Application for Proposed Alterations to Listed Buildings Consent 6/2019/0218/LB at Northaw House, Northaw

I have today submitted an application pursuant to S19 of the Planning (Listed Buildings and Conservation Areas) Act 1990, seeking an altered listed building permission for residential development at Northaw House, in relation to the approved plans under Condition 4, relating to application 6/2019/0218/LB, as amended by 6/2020/0930/VAR.

The Applicant, LW Developments, wishes to make some minor changes to the approved new-build houses in a part of the site referred to within the application documents as the "settlement area". The changes proposed by this application relate firstly to windows and doors on plots 21-26, secondly to the layout of plots 24 and 25 and lastly the access arrangement around the "settlement area" and the layout of car parking spaces. The table below sets out the proposed changes:

Scale	A1	Date	18/12/2020
1:50	A3		
Drawn		Checked	DR
BW			
Drawing Number	Revision		
8250-SAU-SU2-1010-DR-A	P2

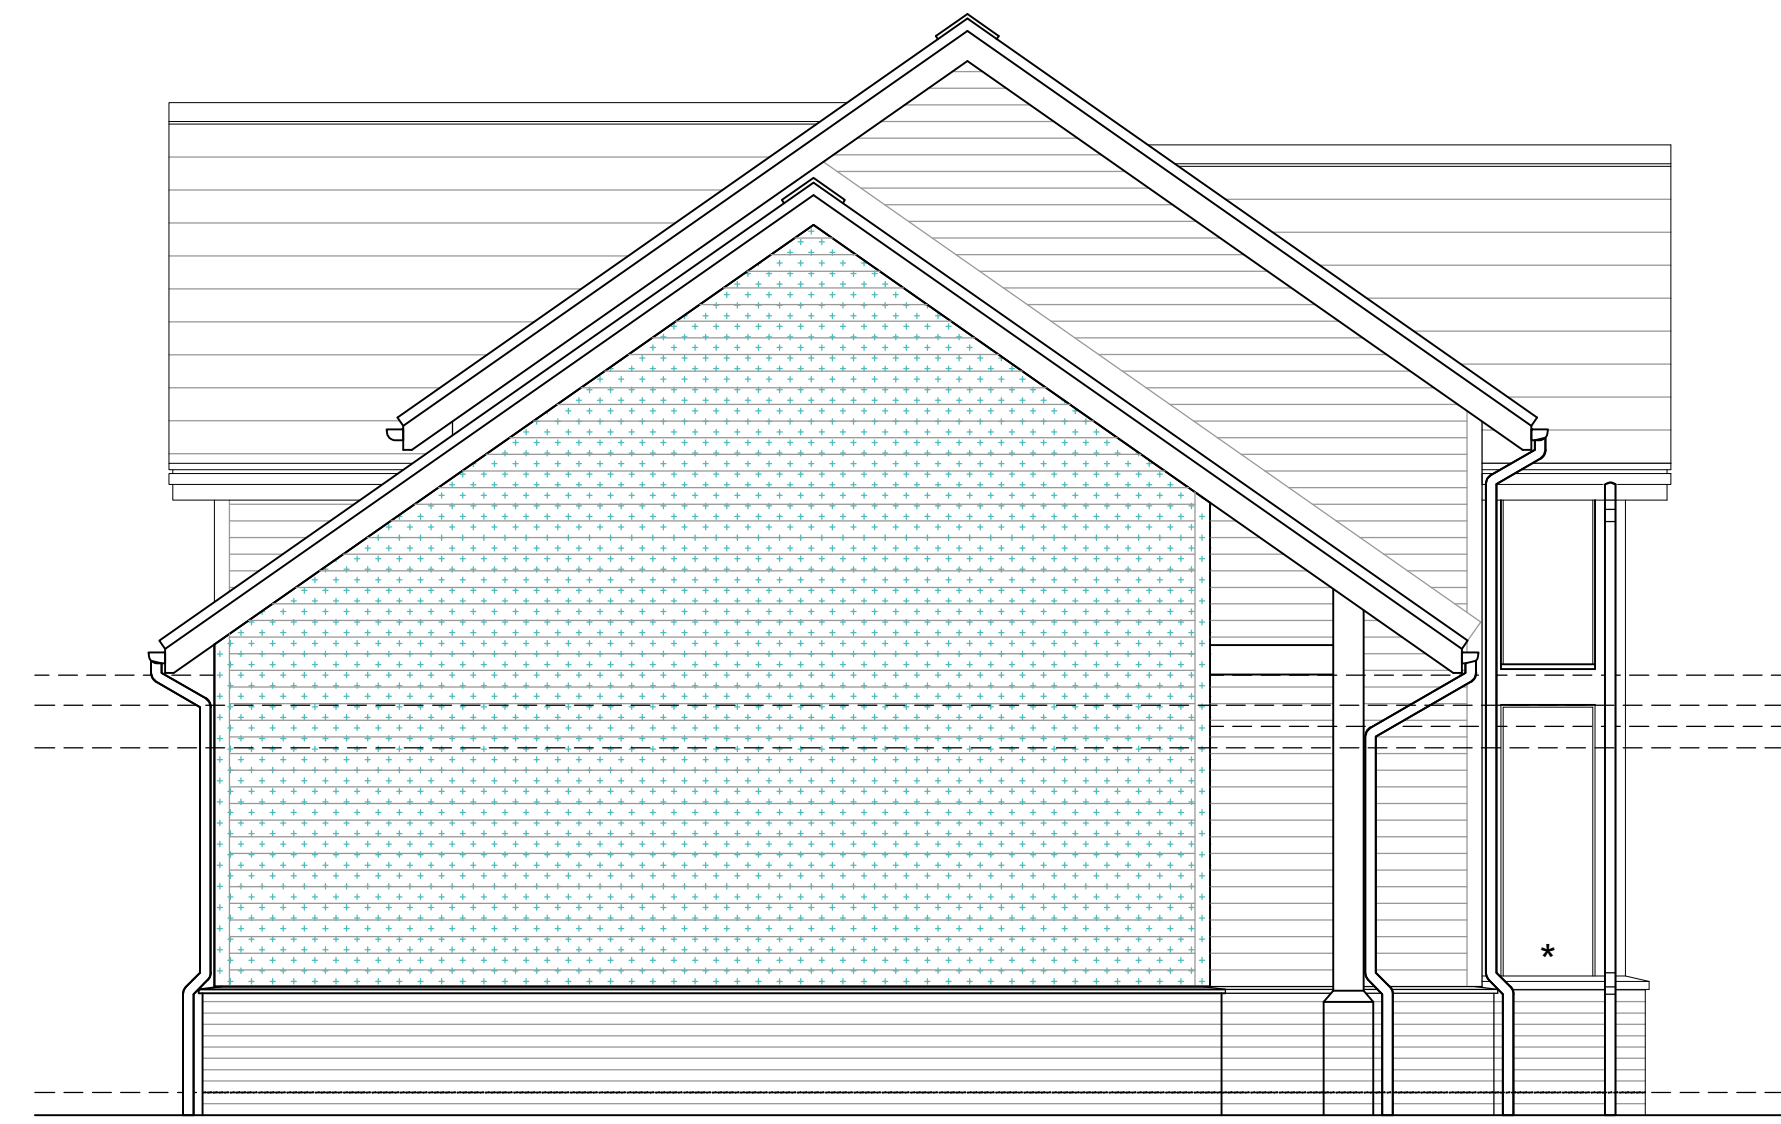
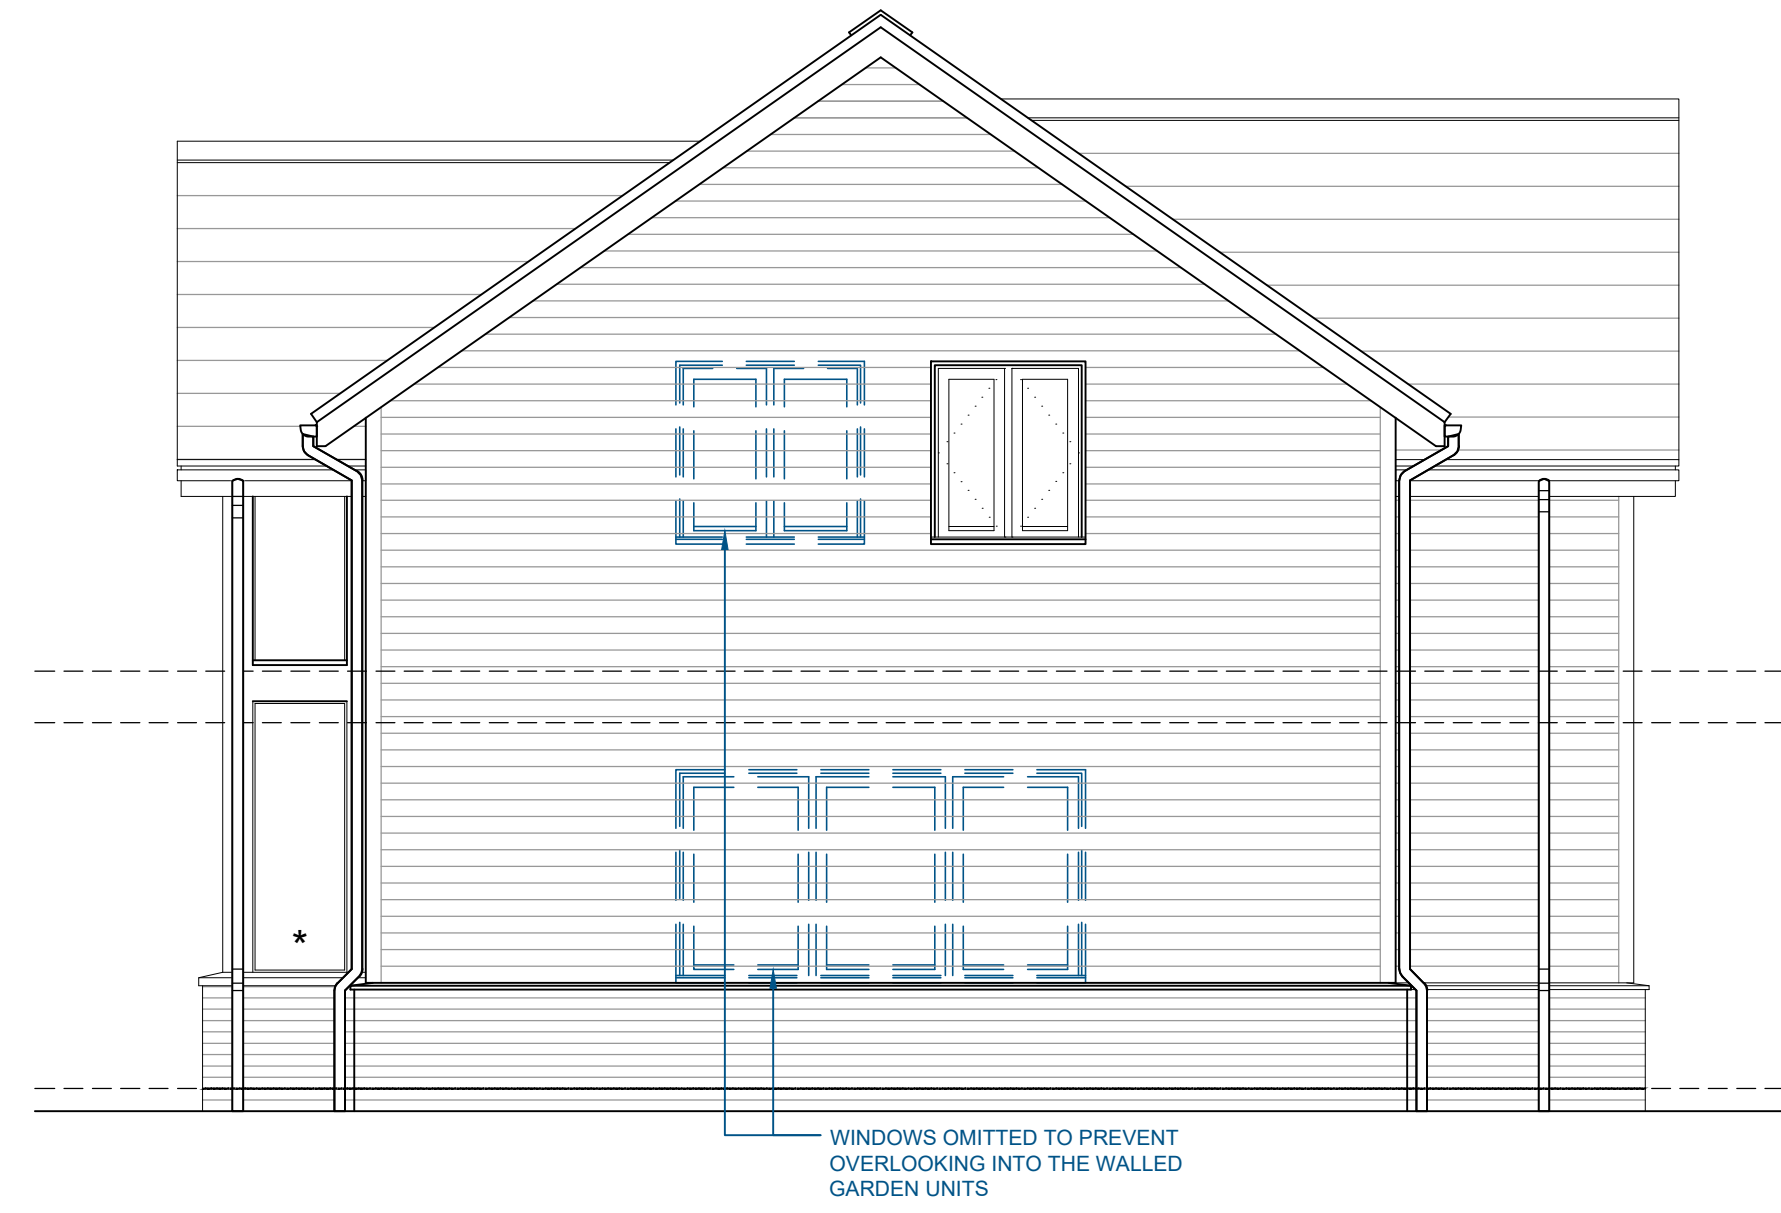
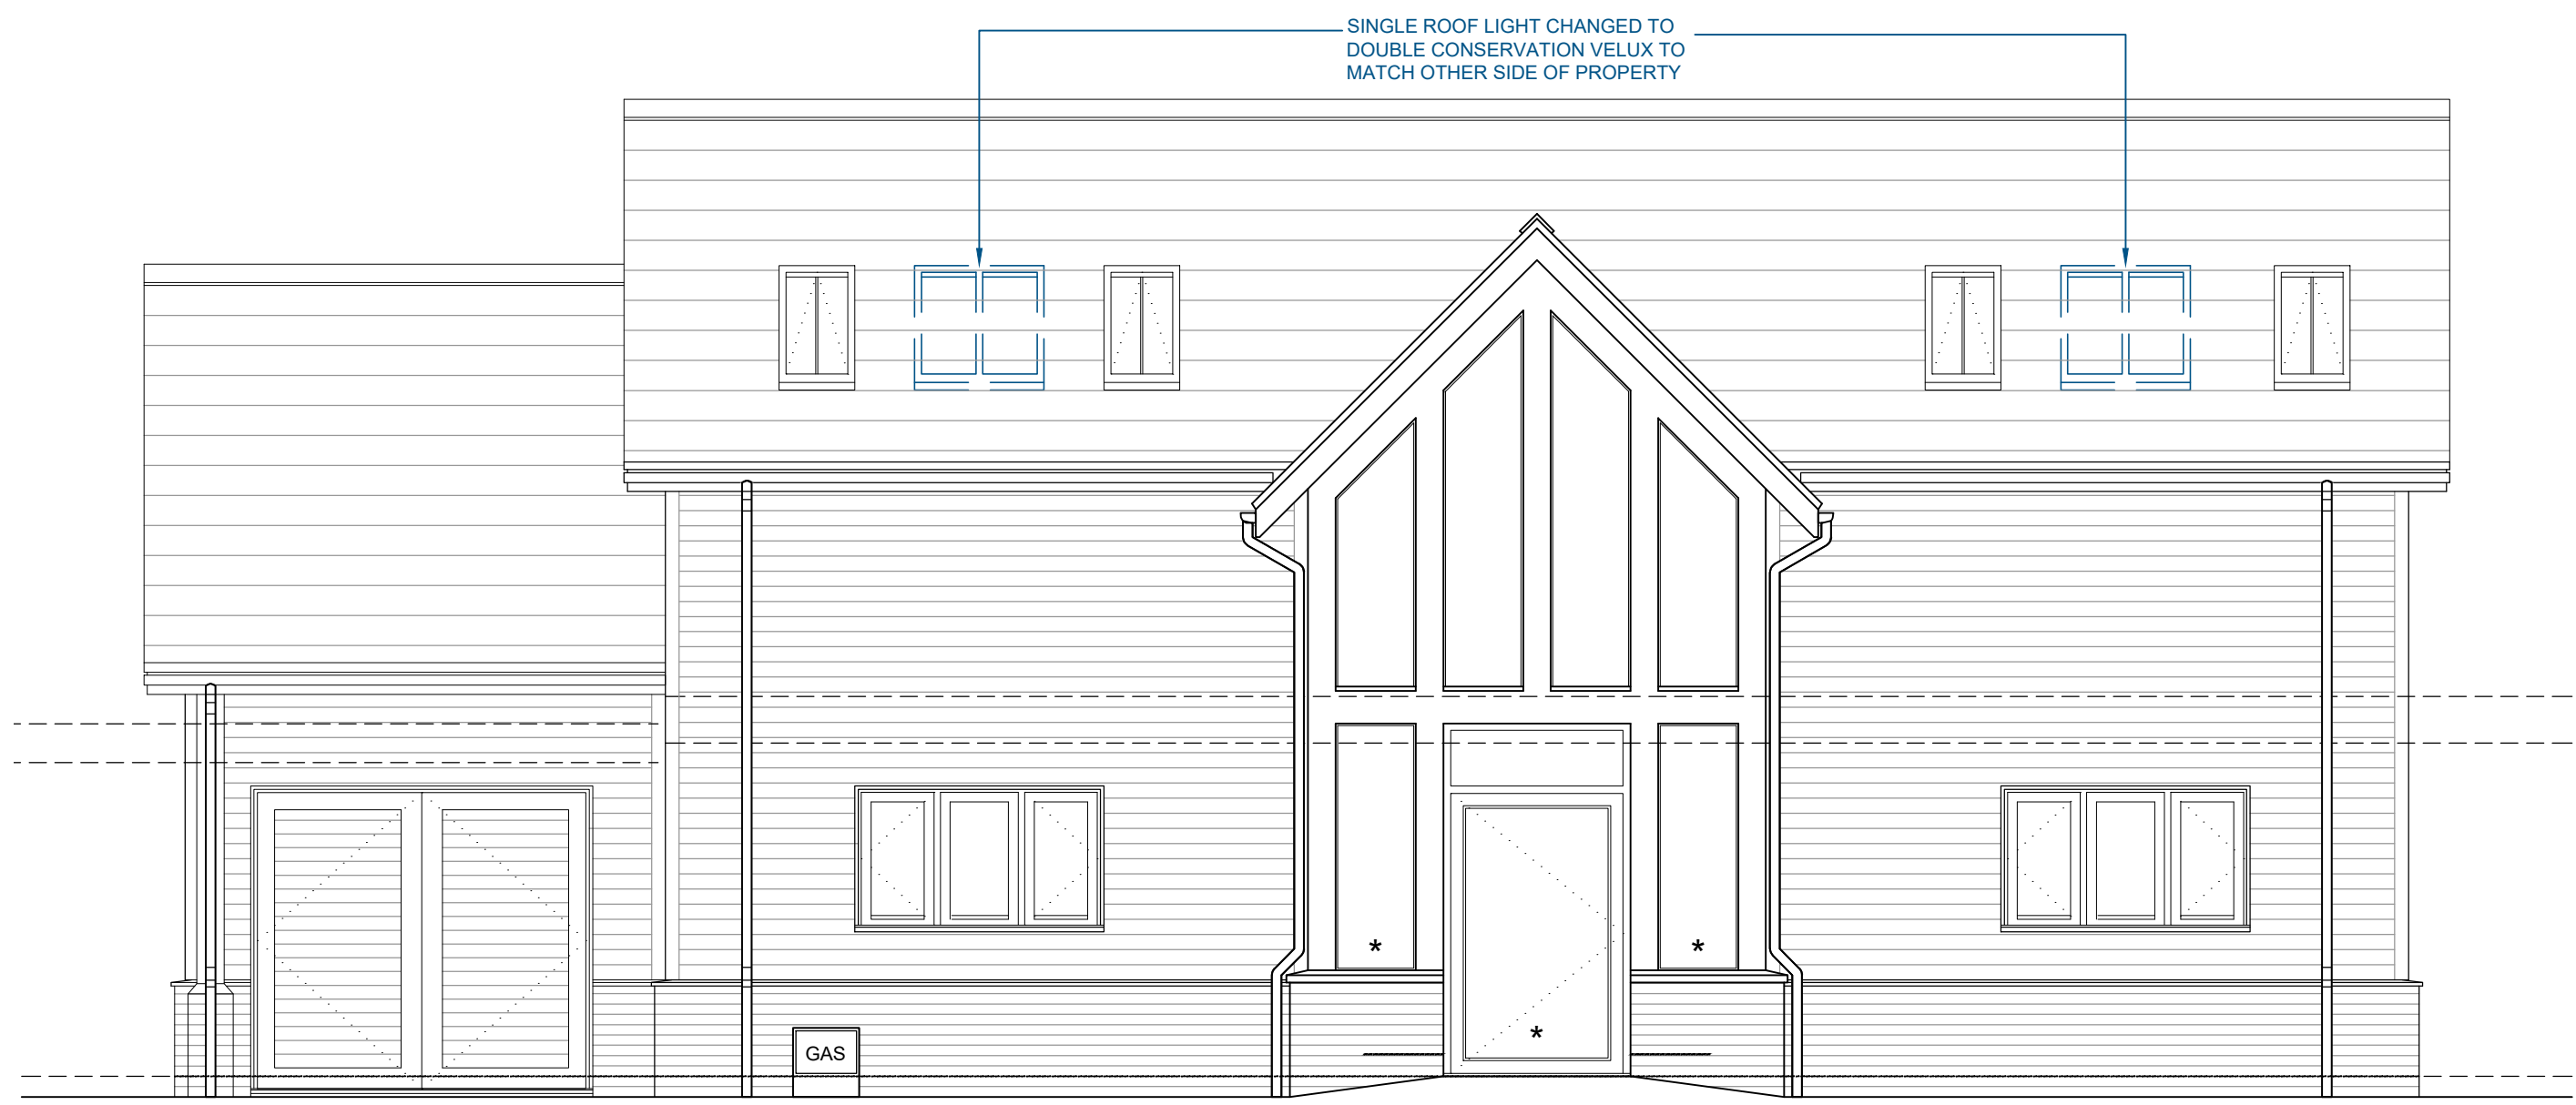
<p>Switching of doors and windows leading to patio area.</p> <p>Omission of windows on side elevation.</p>	<p>To better accommodate furniture within the rooms.</p> <p>To provide privacy from road views, and better accommodate furniture.</p>		
Settlement Unit 2 (Plot 24)	<p>Replacement of normal Velux with conservation Velux windows.</p> <p>Omission of windows on side elevation.</p>	<p>To improve the building's appearance.</p> <p>To prevent overlooking of walled garden houses.</p>	16_254_PL64C	8250-SAU-SU2-1010-DR-A-P2
Settlement Unit 2 (Plot 25)	<p>Replacement of normal Velux with conservation Velux windows.</p> <p>Omission of windows on side elevation.</p>	<p>To improve the building's appearance.</p> <p>To provide privacy from road views, and better accommodate furniture.</p>	16_254_PL64C	8250-SAU-SU2-0011-DR-A-P2
Farmhouse (Plot 26)	<p>Removal of two ground-floor windows.</p>	<p>To accommodate the kitchen counter, and provide greater privacy from road views.</p>	16_254_PL55	8250-SAU-FH-1010-DR-A-P2
